PLANNING AMENDMENT

Application No. H11/0126/02/A1
Date Registered 170 APR 2002
Case Officer DM9

Description: Sun lounge

Amendment: Amended position and door
1:500 Site Location Plan & elevations

AMENDED PLAN TO SUN LOUNGE

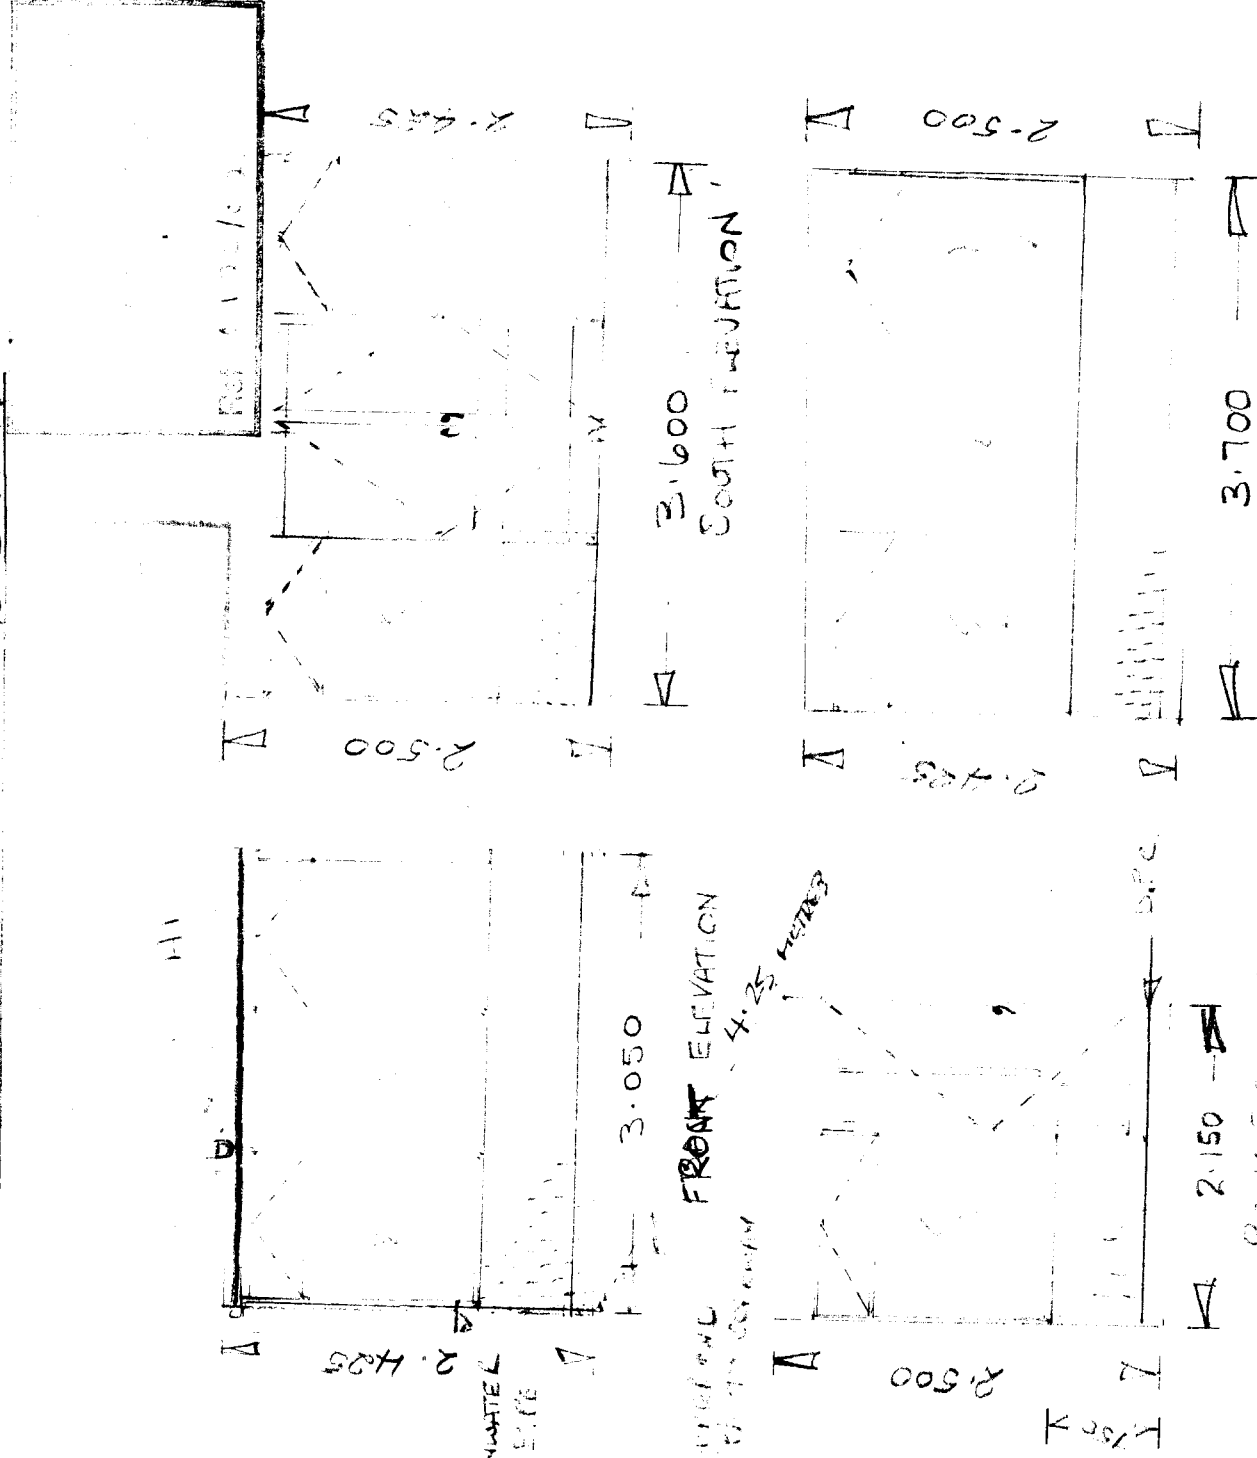
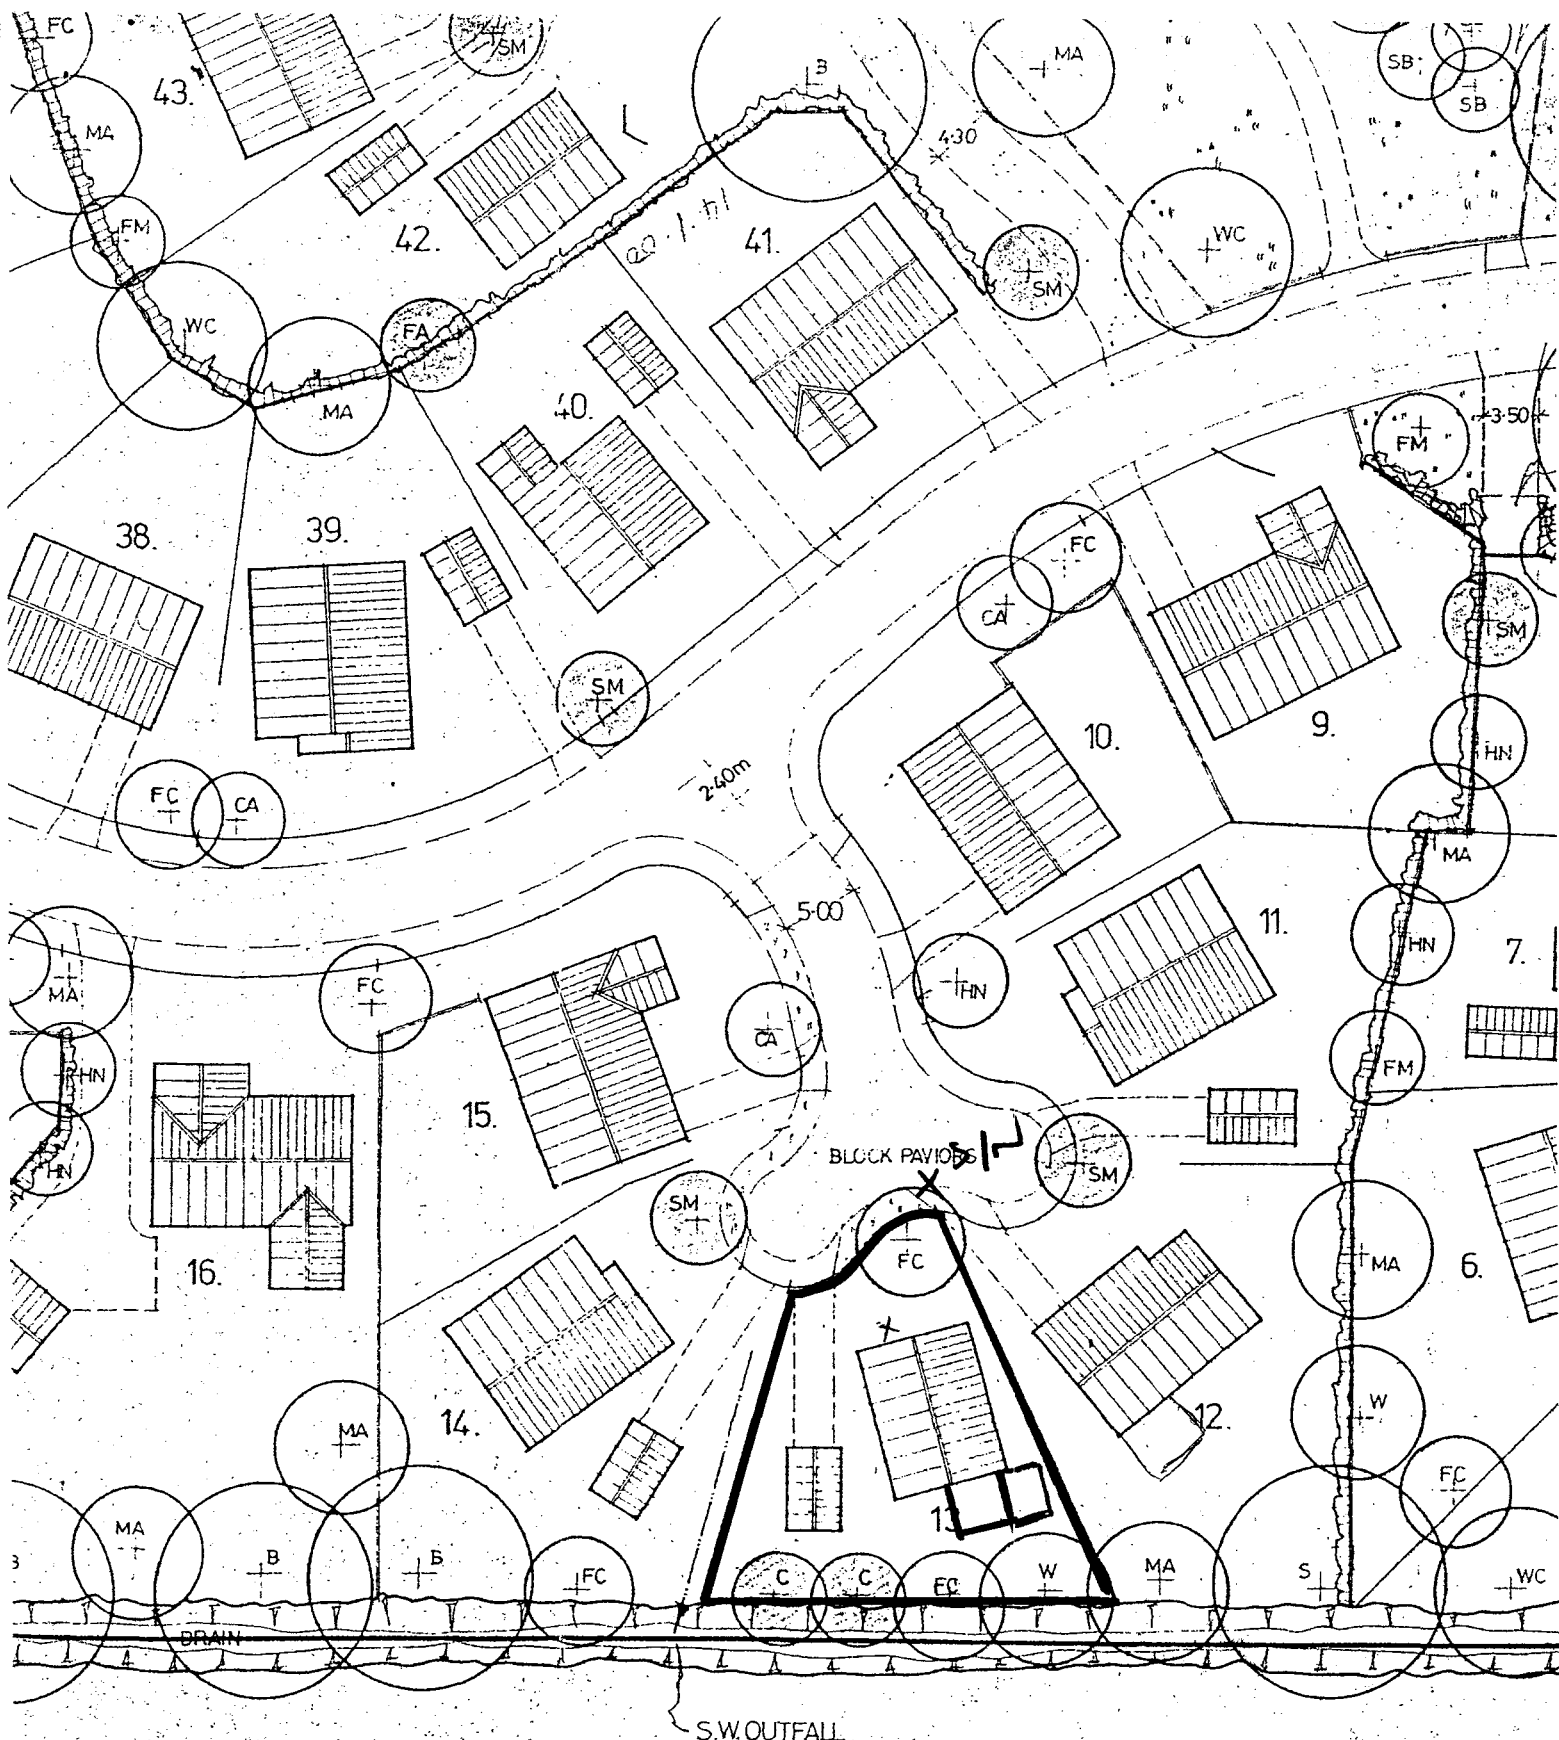
AMENDED POSITION
AND DOOR

The amended details submitted in respect of the above proposal have now been considered and there are no objections to the amendment being implemented to the extent described above.
